**Growth, Environment  
& Transport**

**Re: Application for an Order Granting Development Consent for Stonestreet Green Solar – Relevant Representation Summary**

Following the Planning Inspectorate's Rule 8 letter dated 28 November 2024, the County Council wishes to submit its Relevant Representation summary as its submission was over 1,500 words.

Drawing Title:  
Illustrative Layout Plan  
Sheet 4 of 5

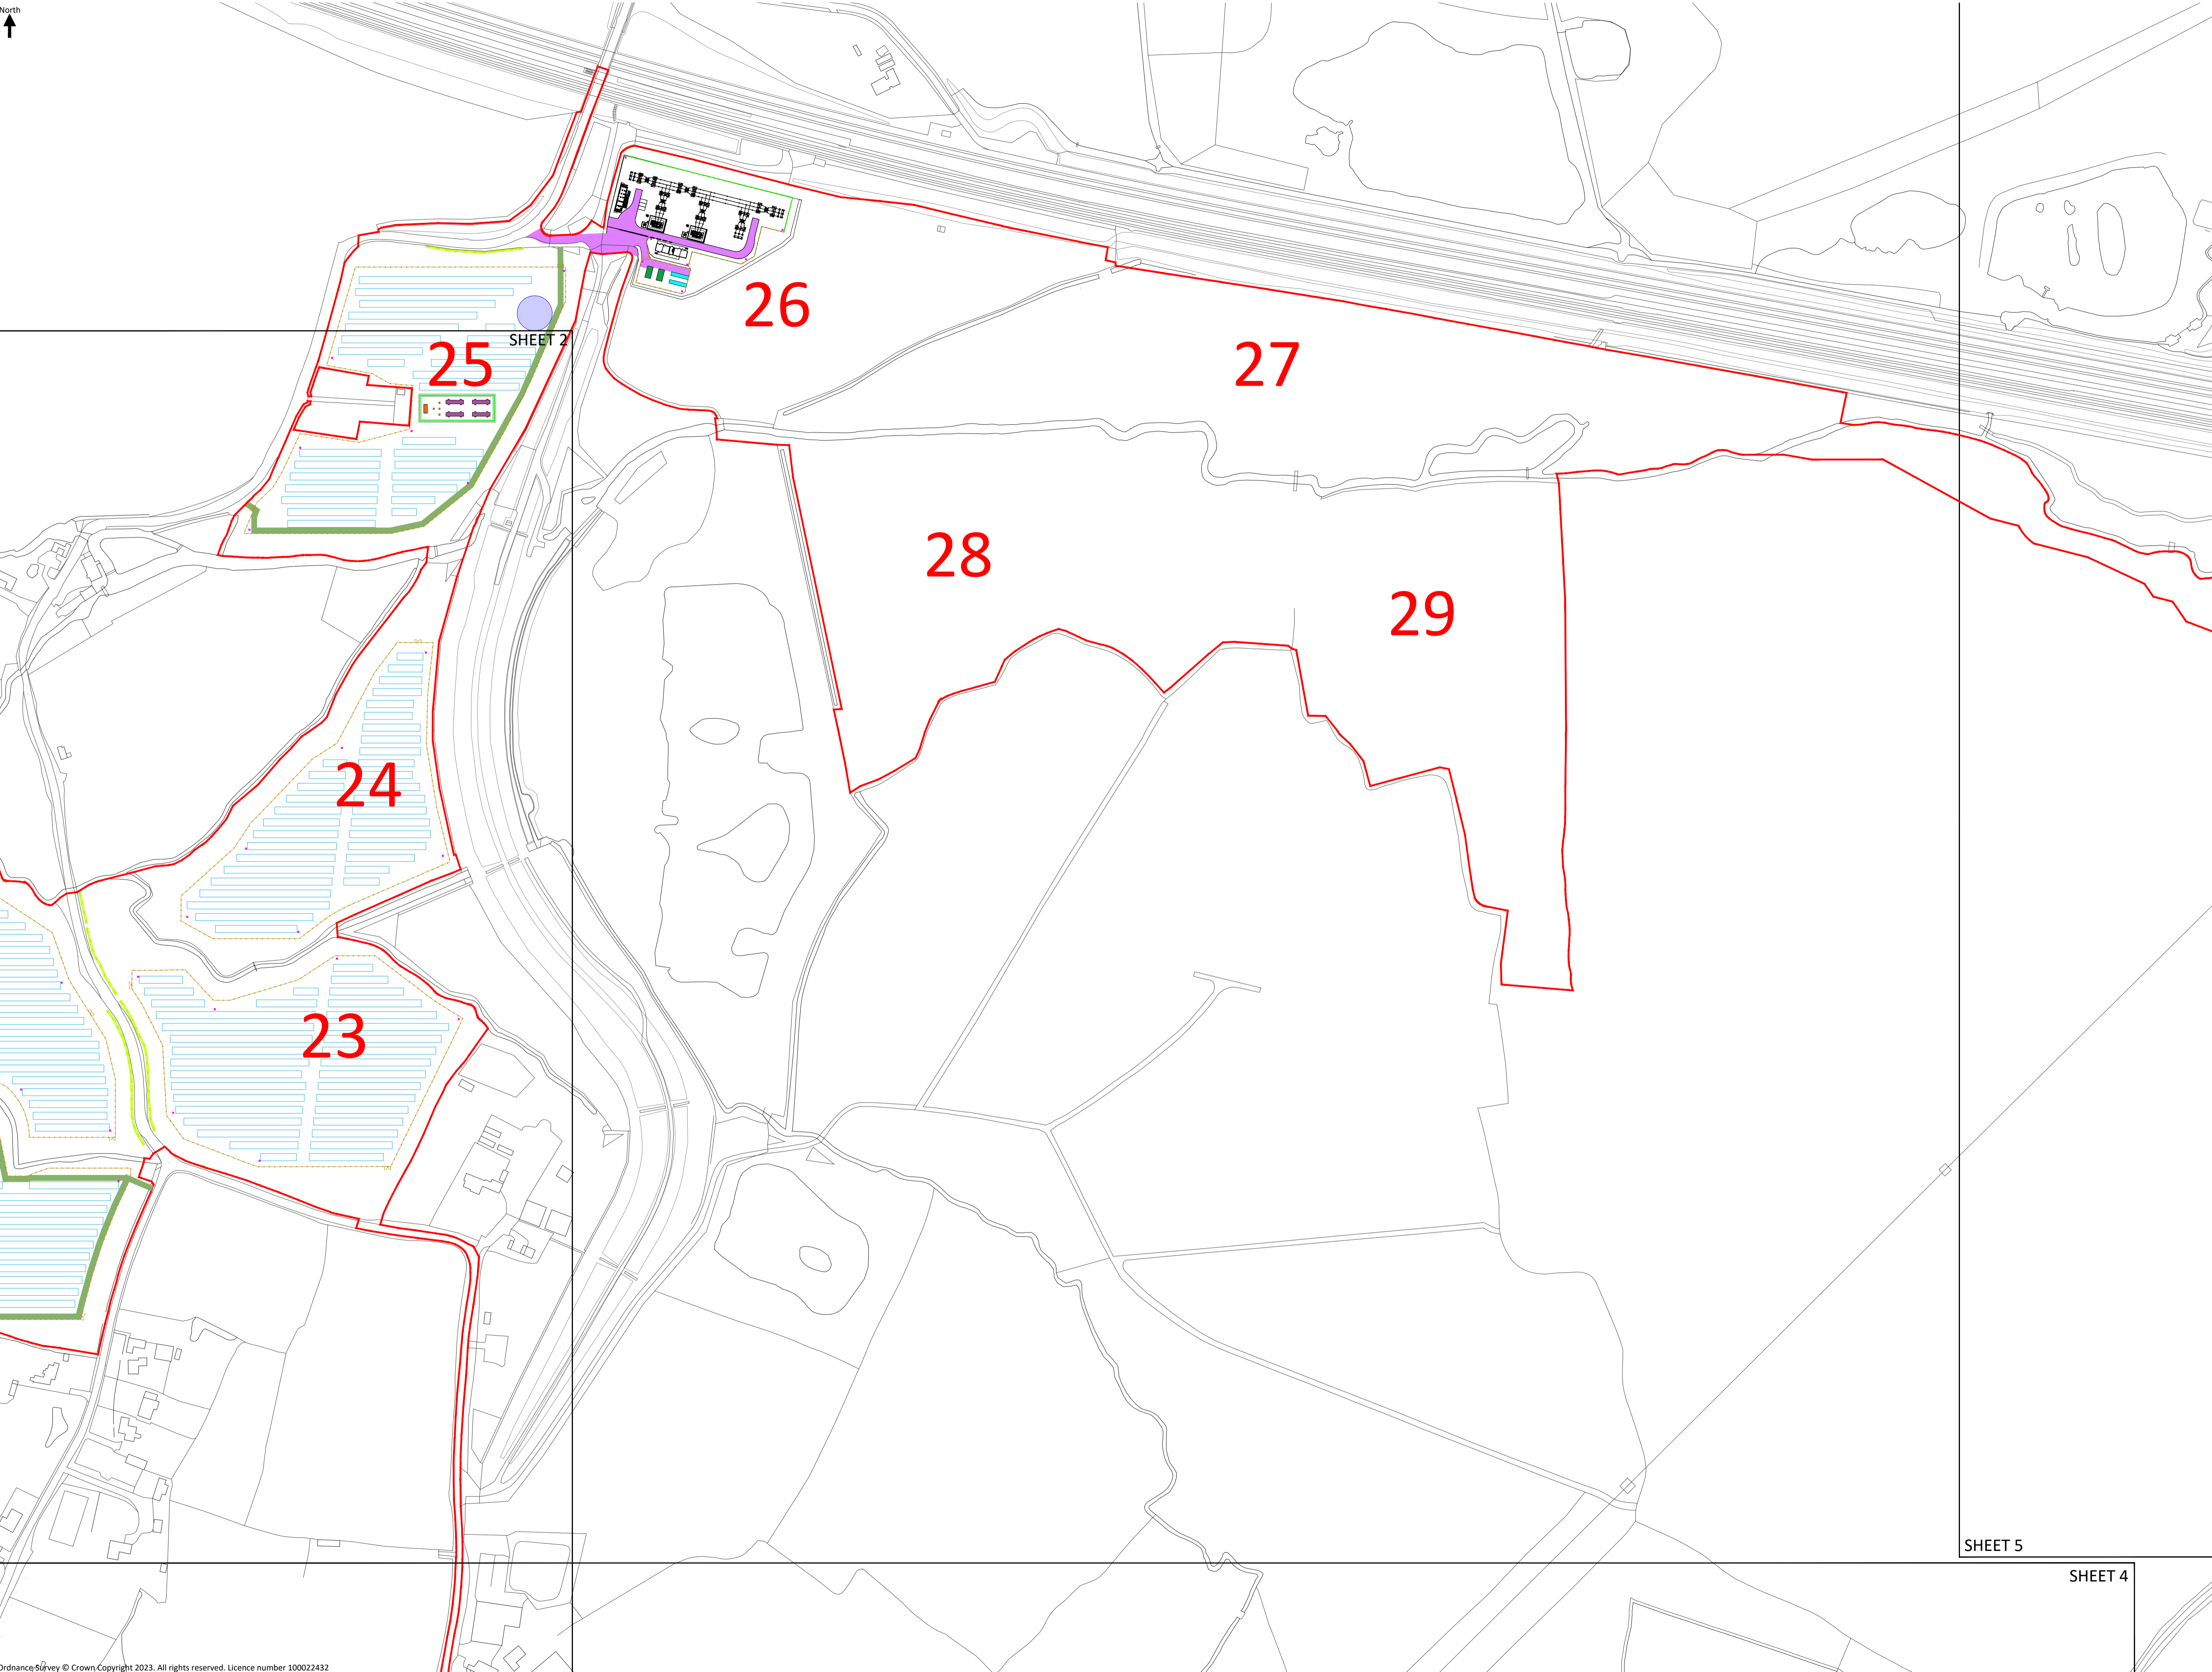
For the five month construction period to deliver the south-east cluster (fields 20, 21 and 22), the OCTMP confirms that escort vehicles will be used to manage traffic and enable passage of the right-angled bend on Goldwell Lane. The stated number of construction workers using this road is not considered by the Local Highway Authority to be unreasonable in a rural area.

There are sections of Goldwell Lane that suffer from encroachment by boundary hedges over the highway verge/edge of carriageway - particularly in the vicinity of Goldwell Farm. Similarly, there are sections of the Station Road access route that would benefit from localised cutback. The County Council recommends that these sections should be trimmed back to a reasonable level prior to the start of works such that this vegetation does not prevent users being able to use the full width of the road to pass other large vehicles. This should be included and secured as part of the pre-commencement highway inspections. The applicant requested that the full width of the highway (including verge) is to be included within the works area that is to be approved in several locations. This is to ensure the County Council's previous requests for vegetation cut back can be delivered to maintain forward visibility of turning manoeuvres, mainly at the Station Road site compound entrance, but also to allow site related direction and warning signage.
